CITY OF ALBUQUERQUE

August 1, 2024

Re: Nuevo Atrisco Food Venue/ BUILDING 1
7921 Unser Blvd. NW
30-Day Temporary Certificate of Occupancy
Transportation Development Final Inspection
Architect's Stamp dated 06-03-22 (K10-D058)
Certification dated 07-26-24

Drawing file: K10D058 / Nuevo Atrisco Food Park Central and Unser 04-14-22.pdf

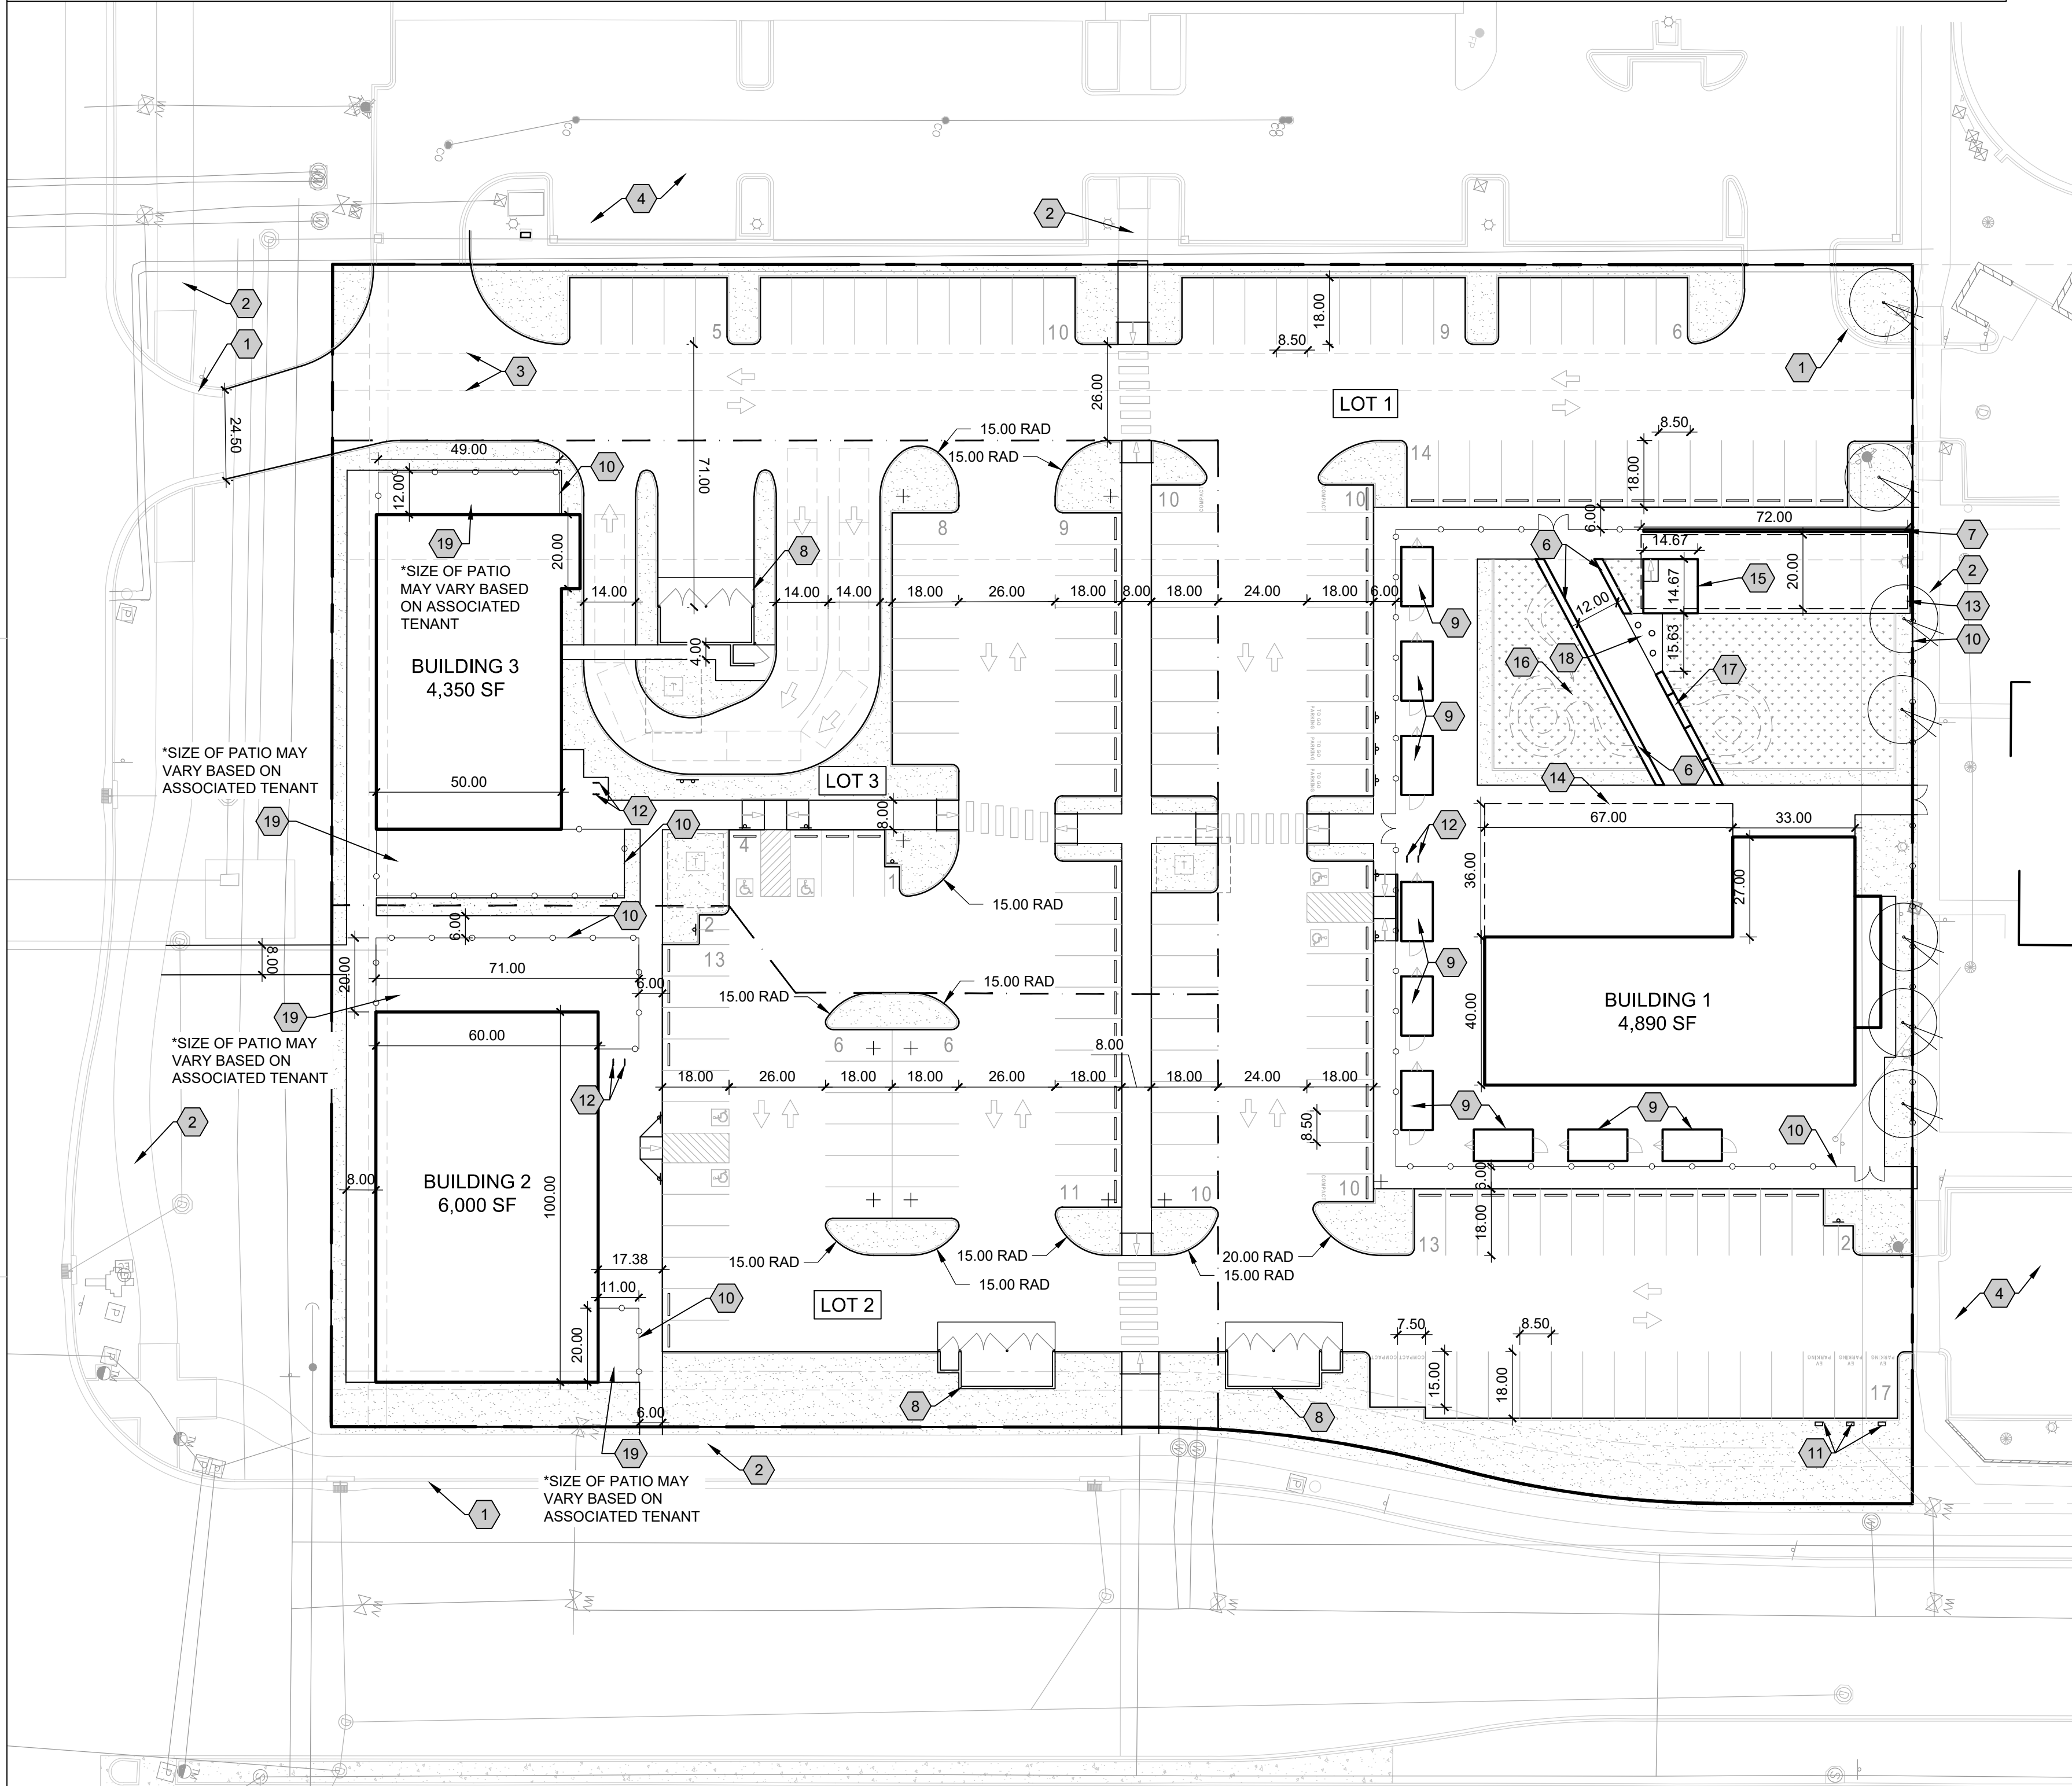
- The ramp at the southeast of Building 1 is not ADA compliant and does not meet city requirements, as the running slope is 9.5% when it should be a maximum of 8.3%. Please reconstruct this ramp to ensure it meets the necessary standard.

- Due to installed light pole, the ADA pathway from the ADA aisle is only 40 in. wide, when it should be a minimum of 48 in. please provide minimum 48 in wide ADA pathway.

Once these corrections are complete, email pictures to malnajira@cabq.gov for release of Final CO.
